EN010158 Rosefield Solar Development

# CSAG Landscape Note for Deadline 3

May 2026

Carly Tinkler CMLI

TITLE:
FIGURE 3.2: INDICATIVE SOLAR PV AND STRING
INVERTER CROSS SECTIONS

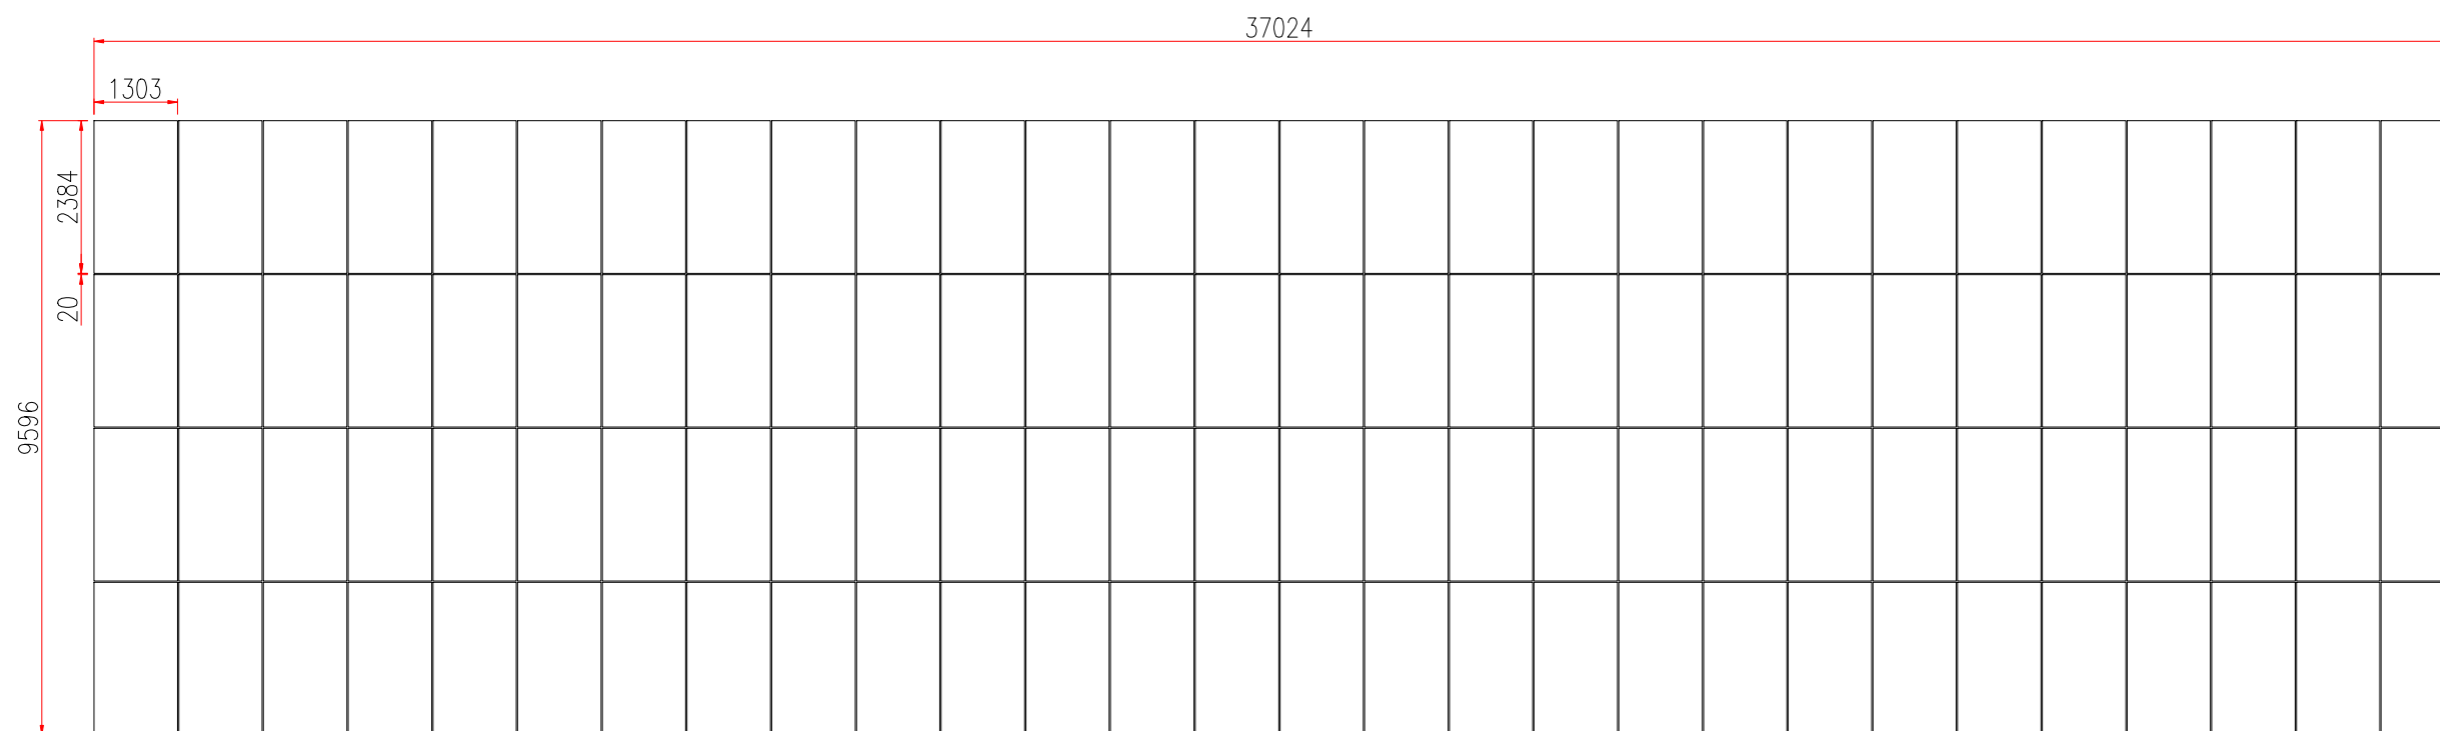
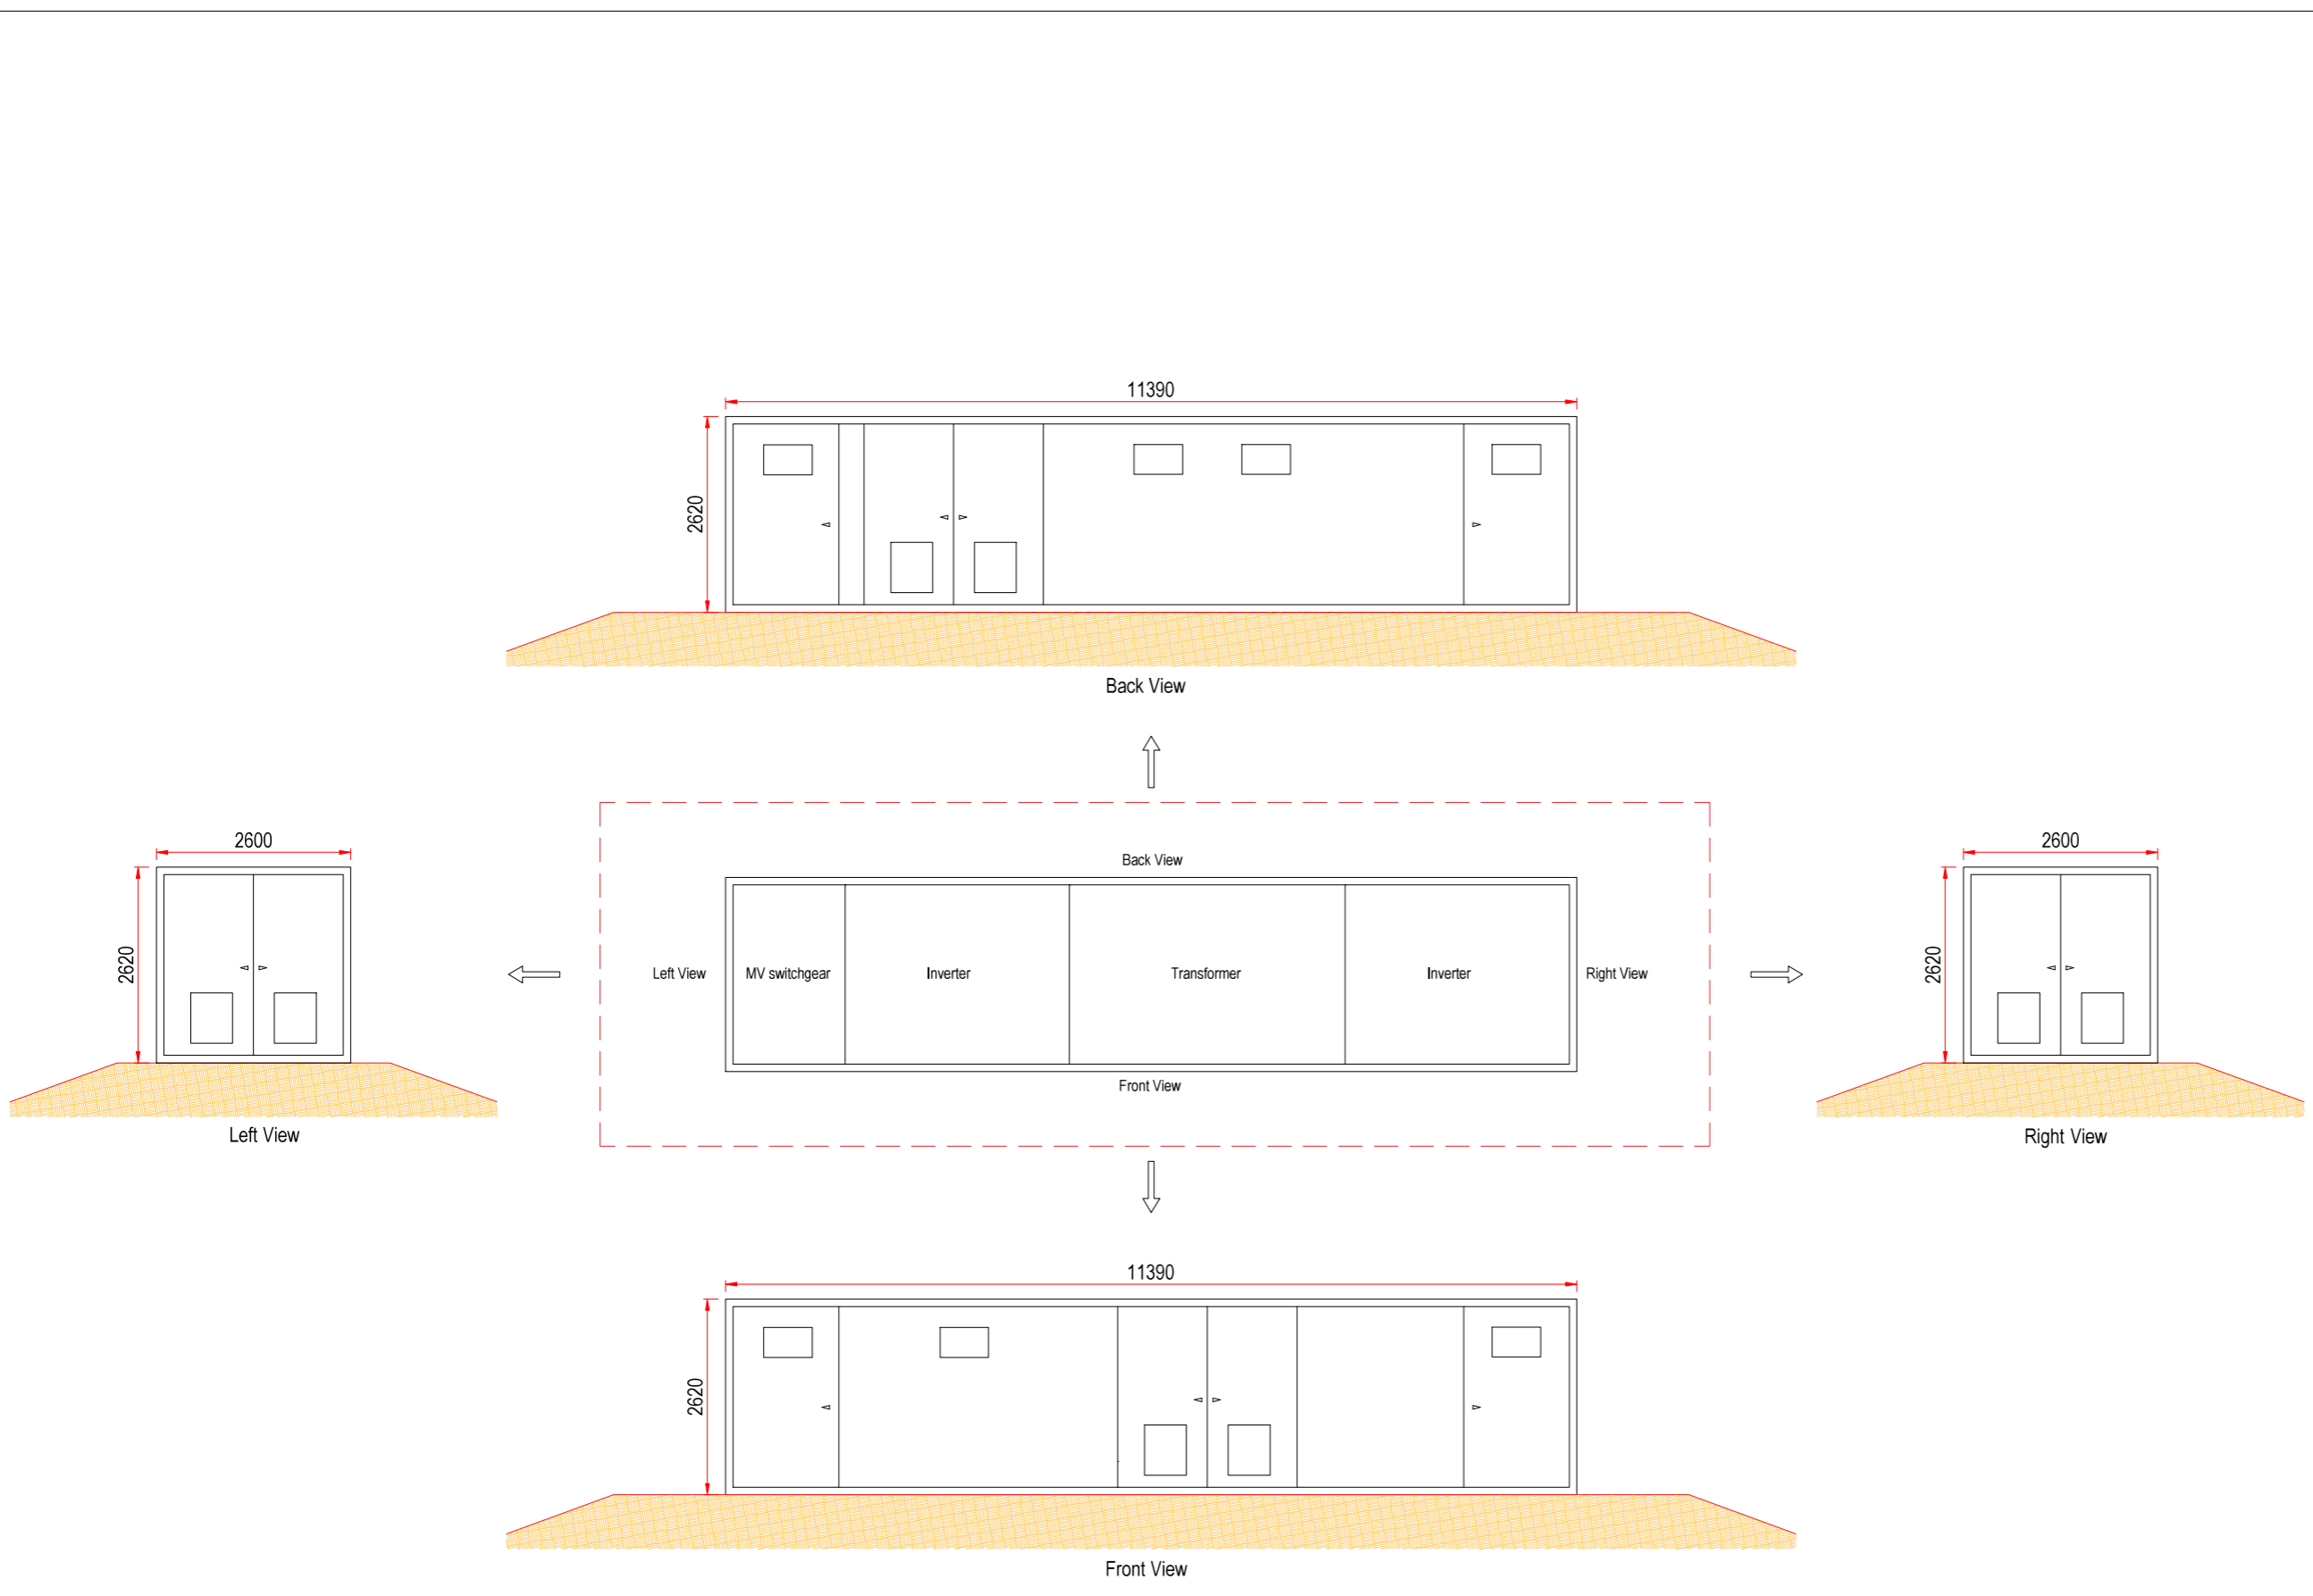
- c) Clarification is required from the Applicant as to whether the 4.5m-high panels proposed in lower-lying areas could be effectively screened by 3 – 3.5m tall hedges (perhaps by way of long sections / visualisations) – also below.
- d) Query about the effectiveness of the proposed woodland screen planting at Year 10 of operation, and whether Year 15 or Year 25 would be more appropriate.

If the Applicant does produce the visualisations, they should include views along PRowS crossing the parts of the site where 4.5m high panels are proposed. Note that 4.5m is the height of a double-decker bus / an average bungalow. Images should also be produced to show people adjacent to / in front of the 4.5m high panels, to give an idea of scale.
